Subject: Planning Consultation on: BE/7/21/PL

Application ref: BE/7/21/PL

Description: Demolition of outbuilding & change of use of redundant shop to 3 No. two bedroom flats, associated parking & gardens. This site is in CIL Zone 4 (Zero Rated).

Location: 377-379 Chichester Road Bersted PO21 5AT

Drawing: Block and site layout plan- (1:200@A3)

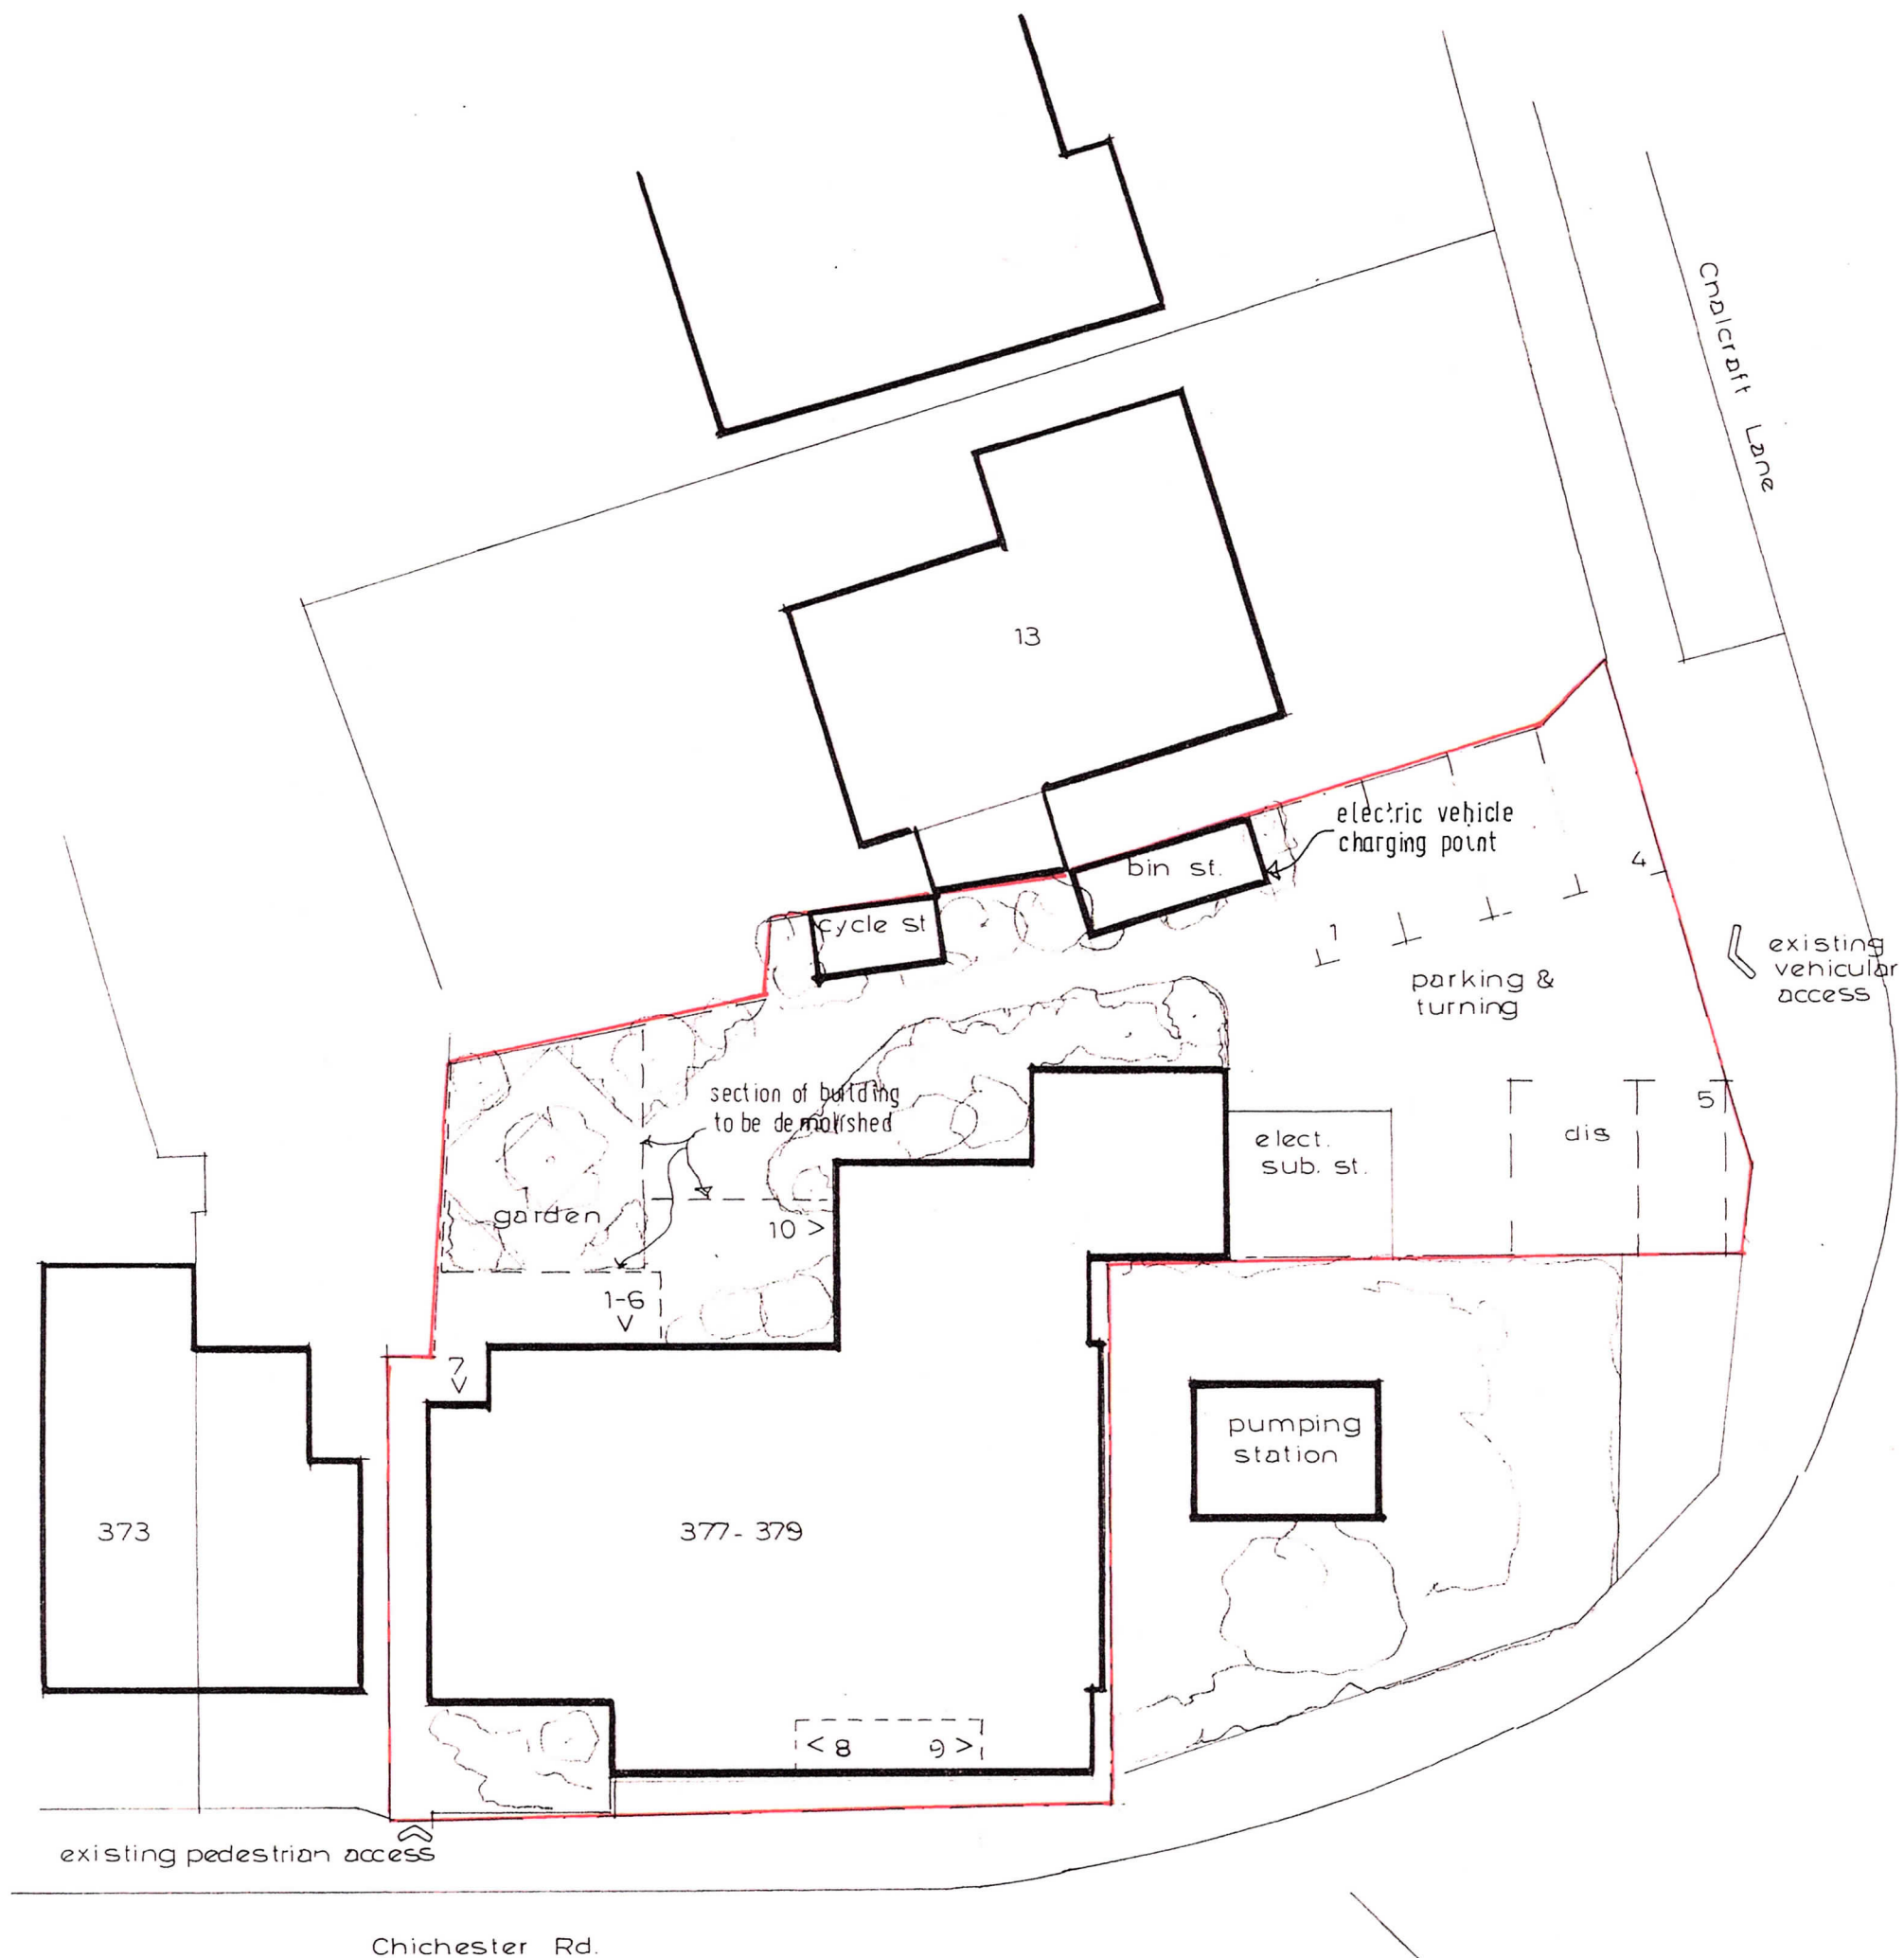
The NPPF para 124/127 relates to good design principles which equally apply to commercial and infill development. The proposals will need to conform to Aruns adopted Design Guide 2021. The documents submitted show a small indicative landscape offer, this would need to be further detailed to provide a scheme which will soften the development and add to biodiversity net gain.

The potential impact of the proposals could be lessened in this location and blended into the surrounding residential setting with further thought given to the landscape offer and greening to enhance this.

Details of the proposed landscape provision as indicated should be submitted for approval. The opportunity to increase the biodiversity of the site and potential screen the proposals should also be considered. Any trees and shrubs specified should be at a size which allows instant impact, but which will establish and mature as the site develops. Landscape details will be required to be submitted in plan form detailing species choice, quantities, planting densities and size at time of planting.

I would recommend the submission of landscape detail to expand on the indicative already shown.
